Include the following:

LANDSCAPE PLAN

Widefield Parks and Recreation
Facility Expansion
705 Aspen Drive, Colorado Springs, CO 80911

L1.0A

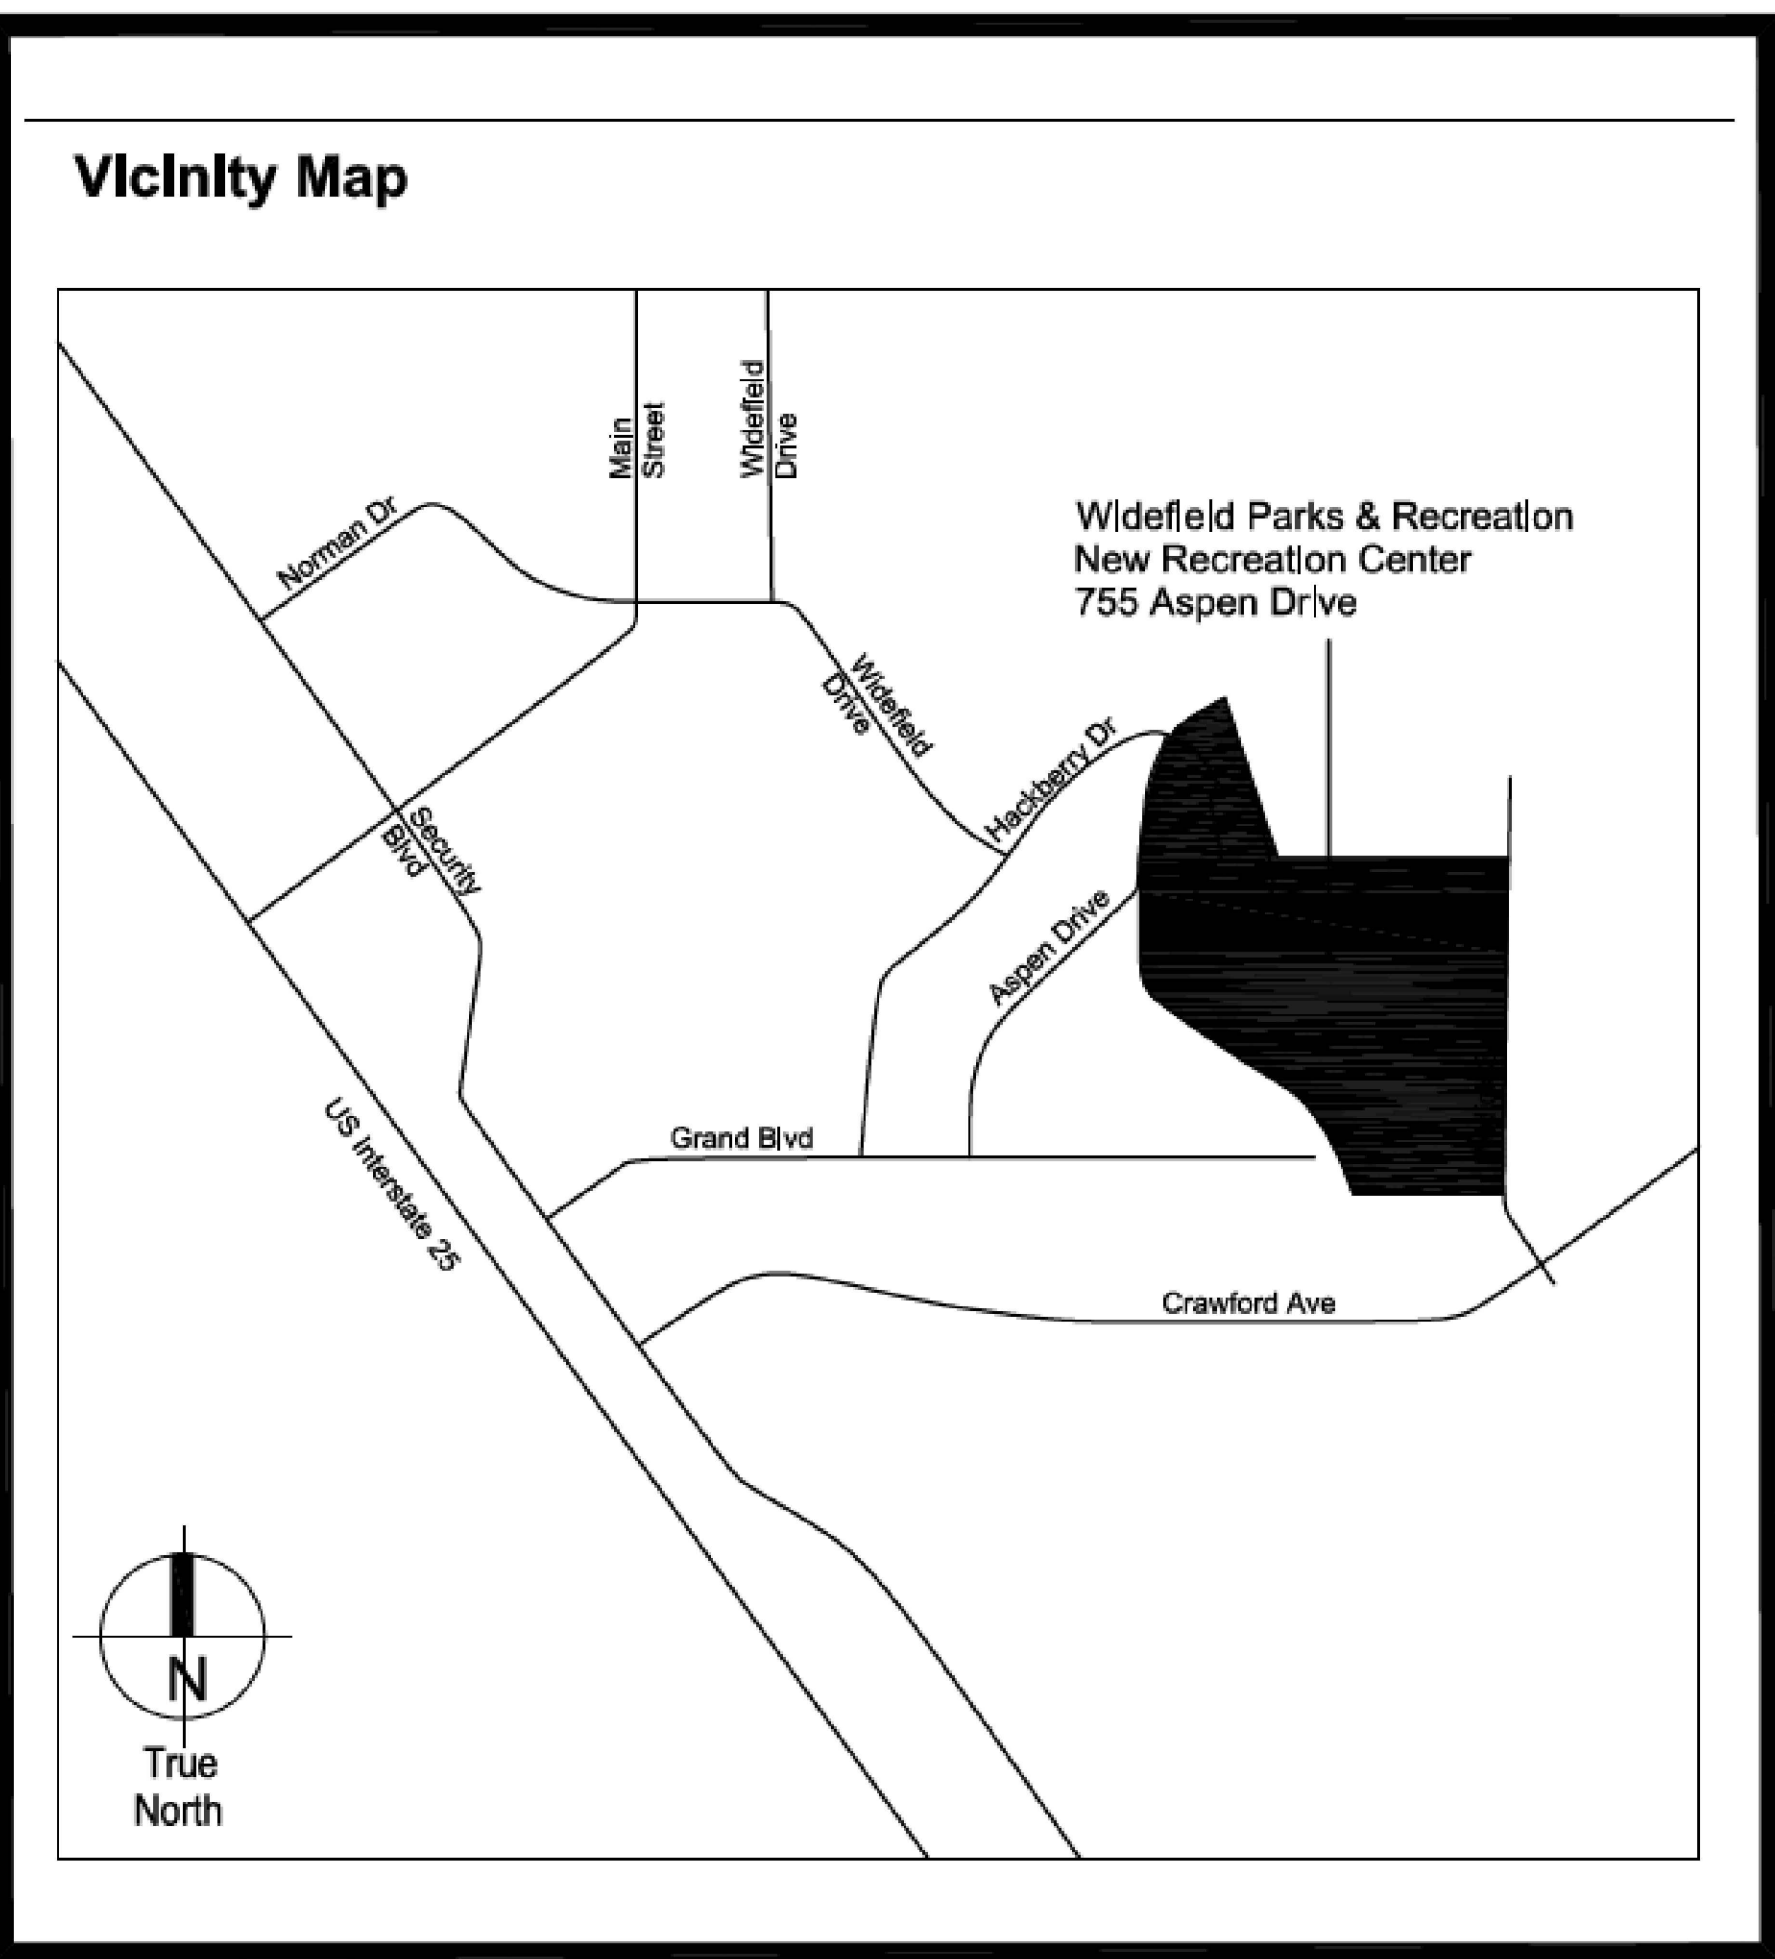
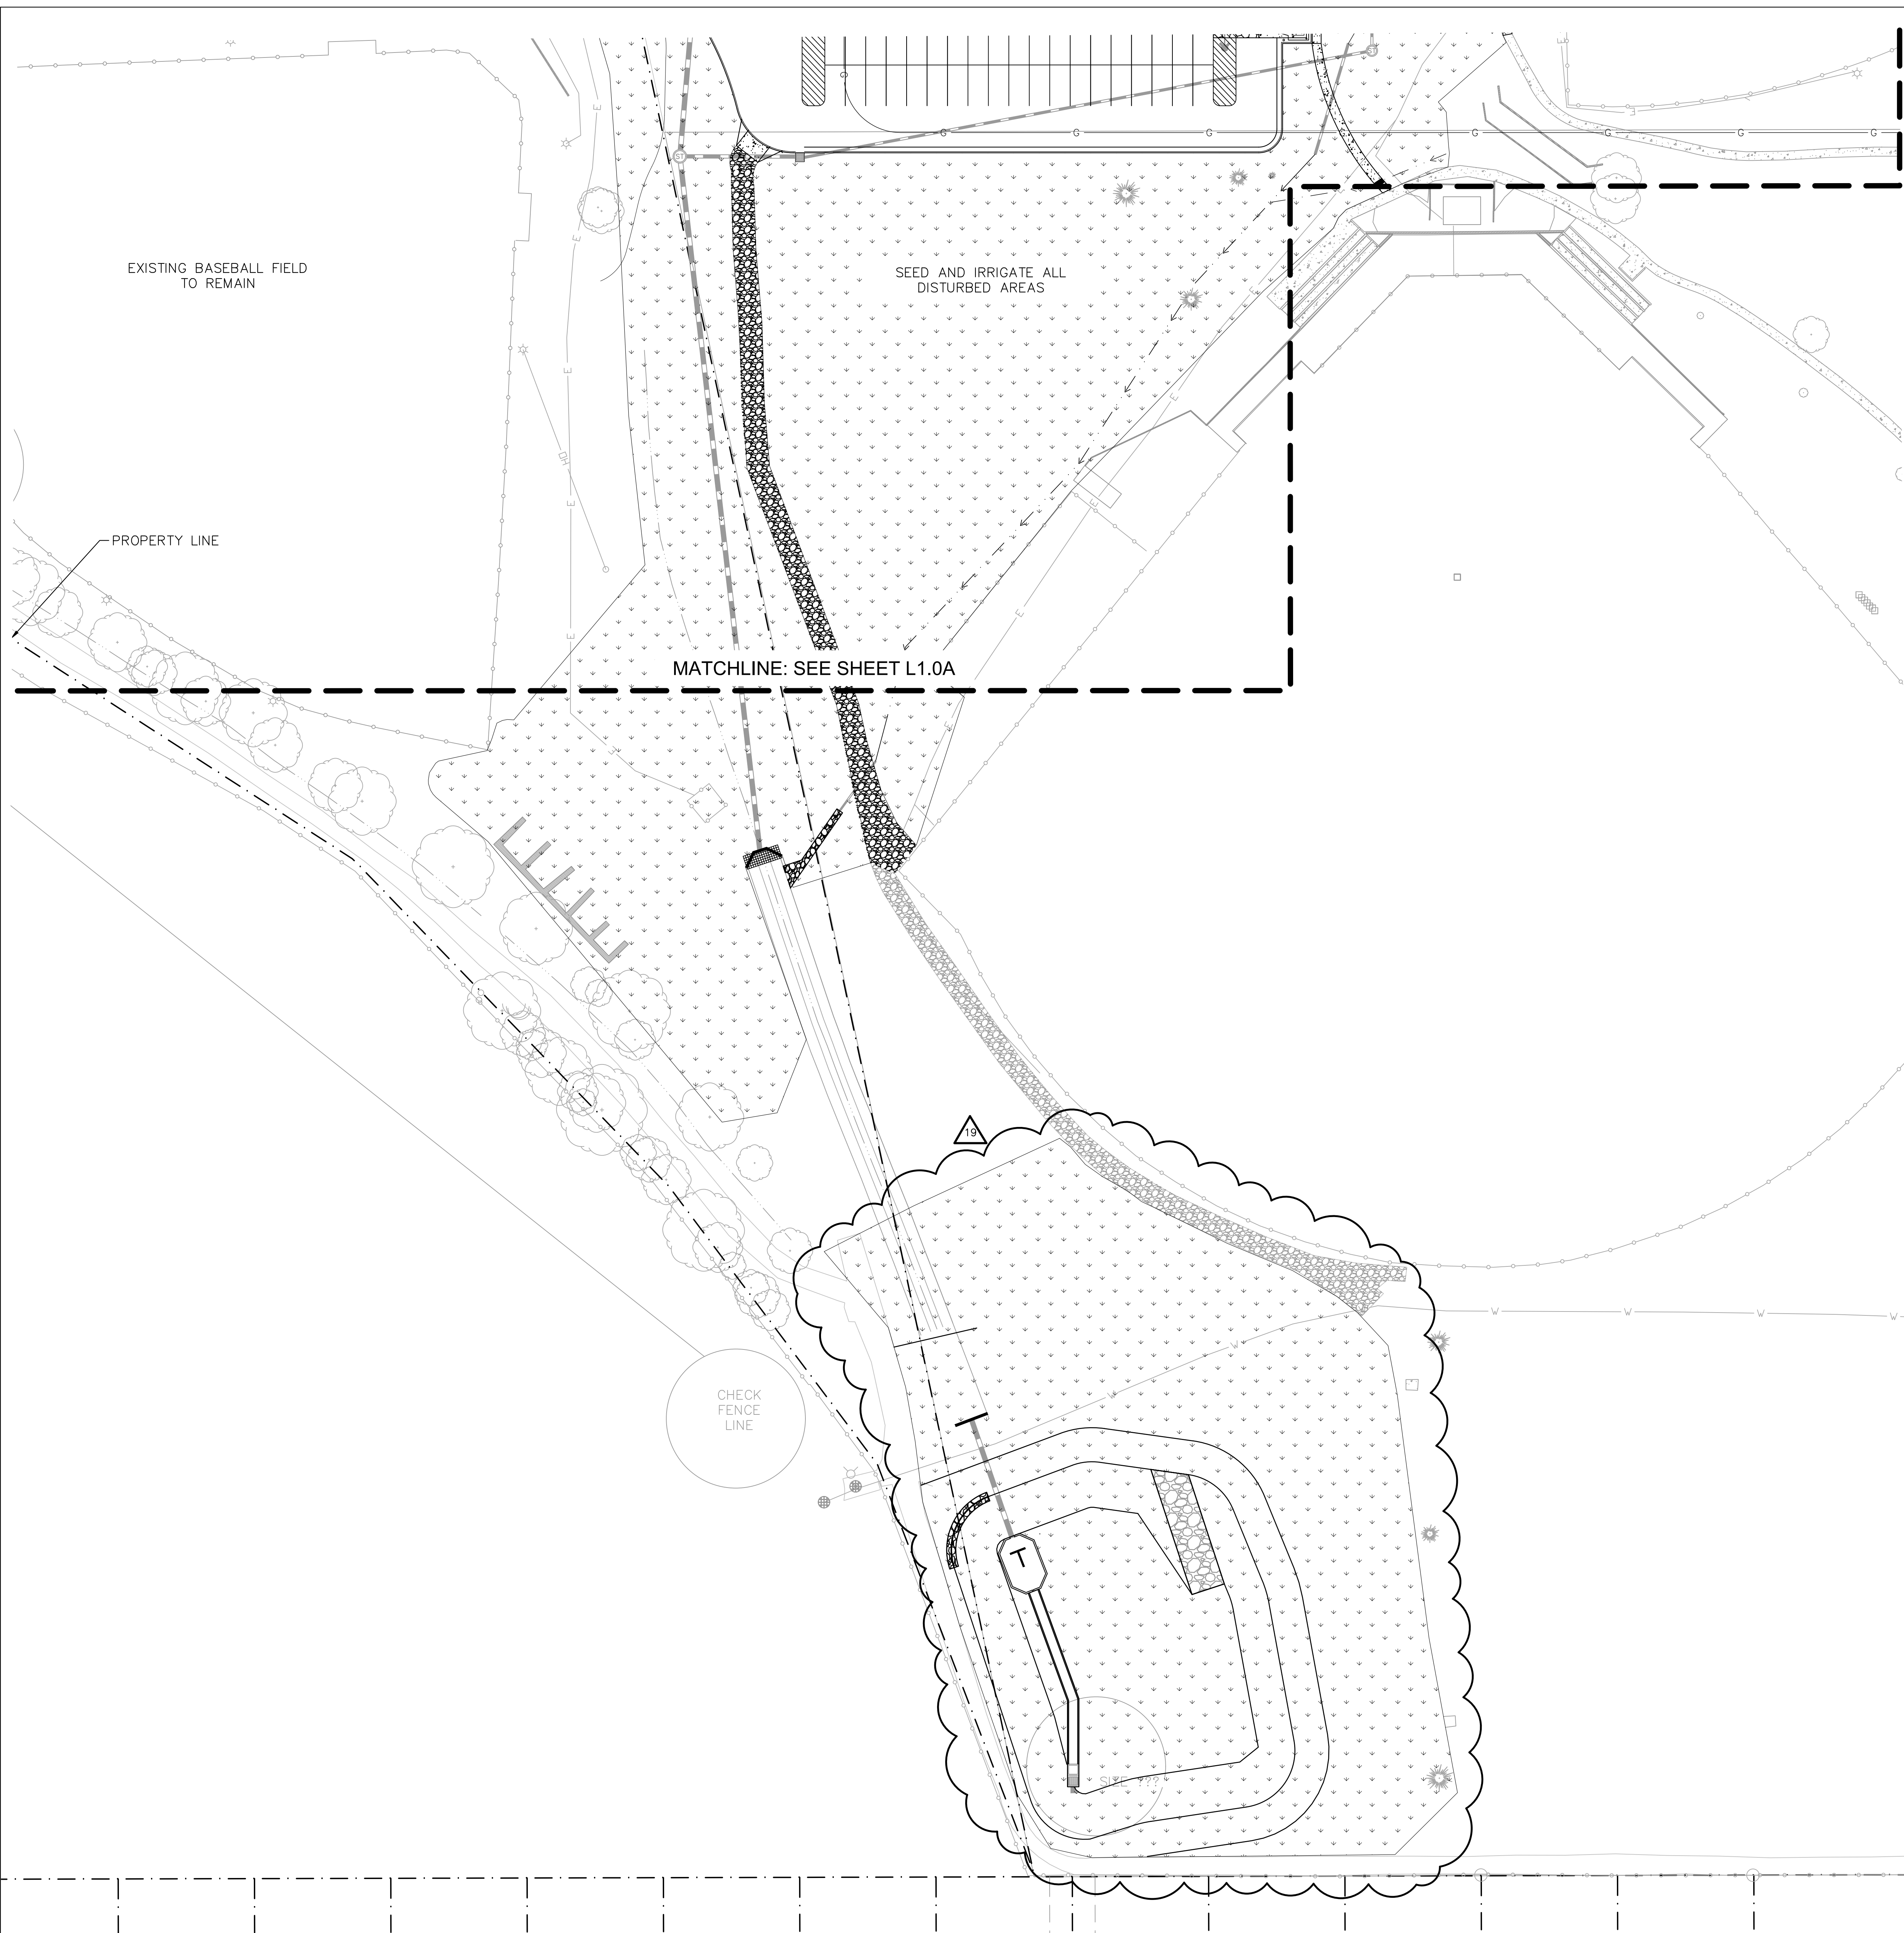
The location of all utilities, walls, fences, exterior parking and loading areas, pedestrian walks or paths, pedestrian-oriented areas, vehicular drives, storm water detention areas, and other manmade elements. Detail drawings of all required structures used for screening purposes (Example: refuse areas, equipment screening, and/or gates). Sight distance triangles and any plantings, signs, walls, structures, or other visual obstructions within the triangles where applicable.

If the application includes a request for approval of an alternative landscape plan, the landscape plan shall include a statement requesting approval of the alternative design and justification for the request unless otherwise provided for in the letter of intent.

KH: The site elements are shown in plan view for reference. A separate plan has been submitted that shows the detention pond details specifically. Sight triangles are not required for private drives and are not shown. No structures are proposed for screening other than typical landscape planting which is shown on this plan.

KH: Not being requested at this time.
